Contact: Iain Rush
Our Ref: DOC2020/149180
Your Ref: MP10_0137 MOD. 14

**Response to Request for Comment
Section 75W Modification Request – Huntlee Stage 1 (MP 10_0137 MOD 14)**

I refer to your email of 1 September 2020 in which you have requested comments regarding Modification 14 to the Huntlee Stage 1 Major Project Approval (MP10_0137). We note that the proposal seeks to remove 10 lots from within residential Stage 5, amend the subdivision layout and remove 27.57 hectares of open space.

INDICATIVE BUILDING AREAS ABOVE
THE INDICATIVE 1% AEP FOR AFFECTED LOTS

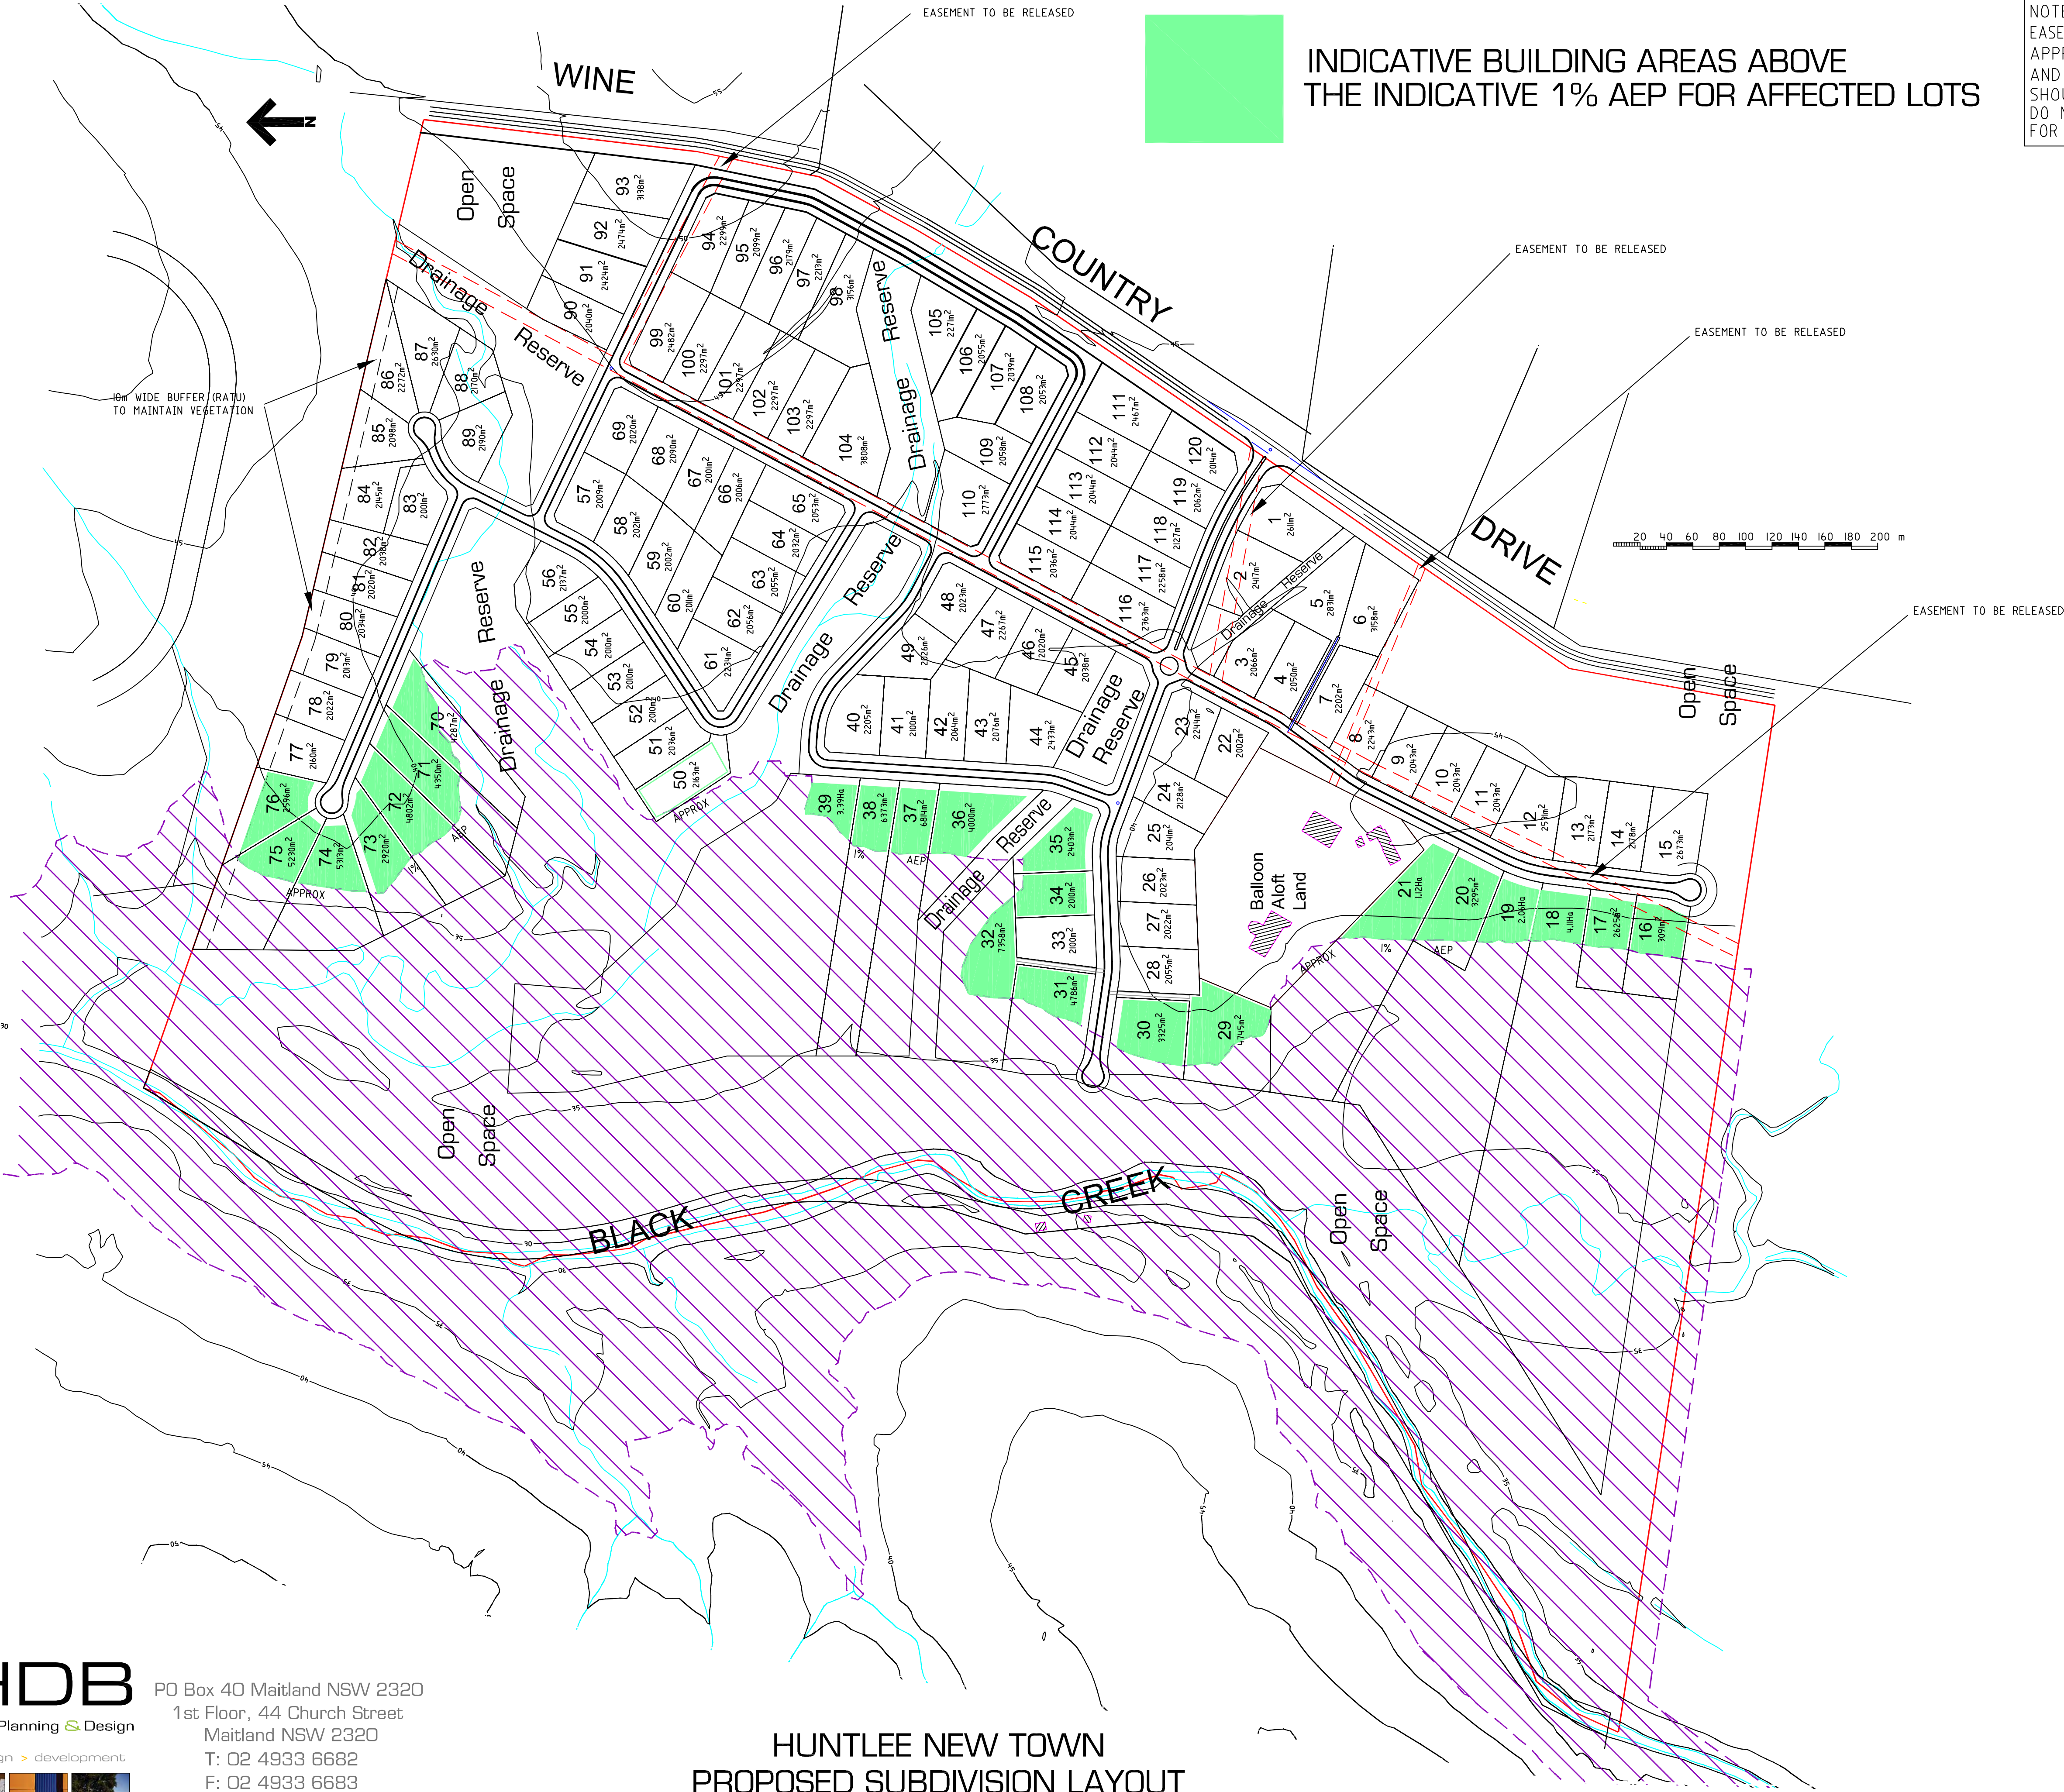
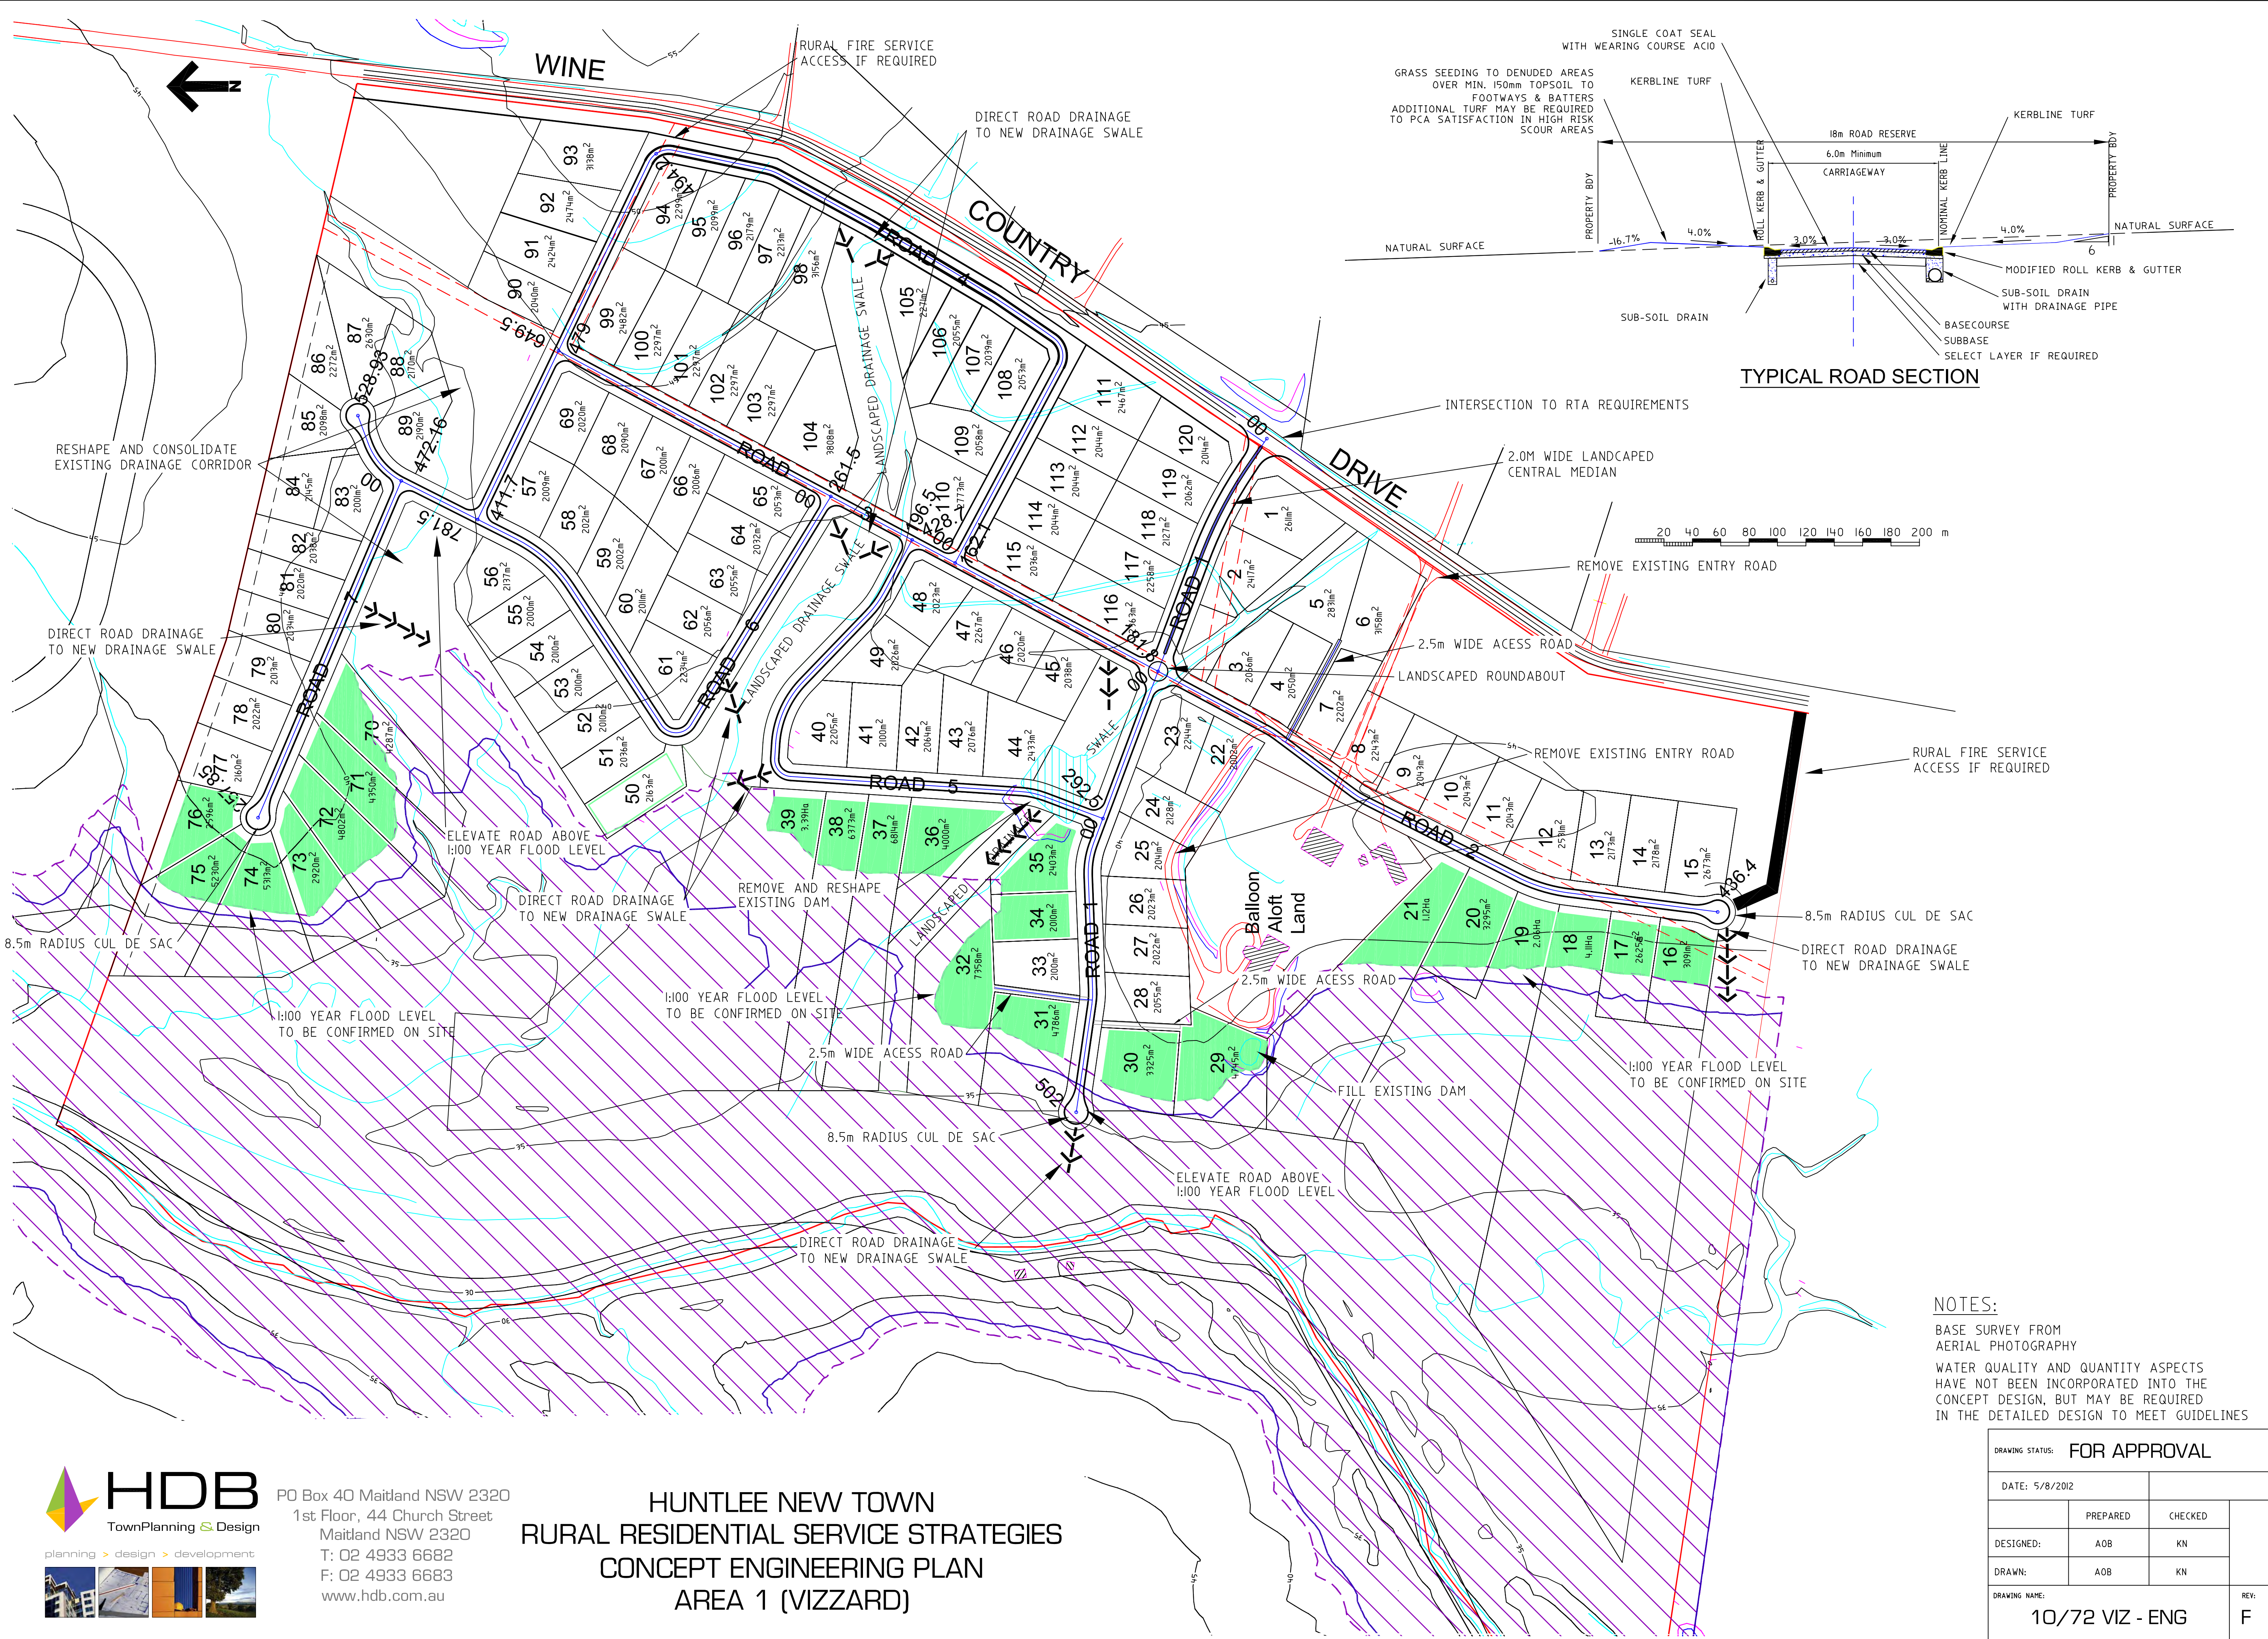
There is also an opportunity for the proponent to consider flood free dwelling envelopes for each of the flood affected allotments in Stage 5 to further minimise the potential risk to life and property.
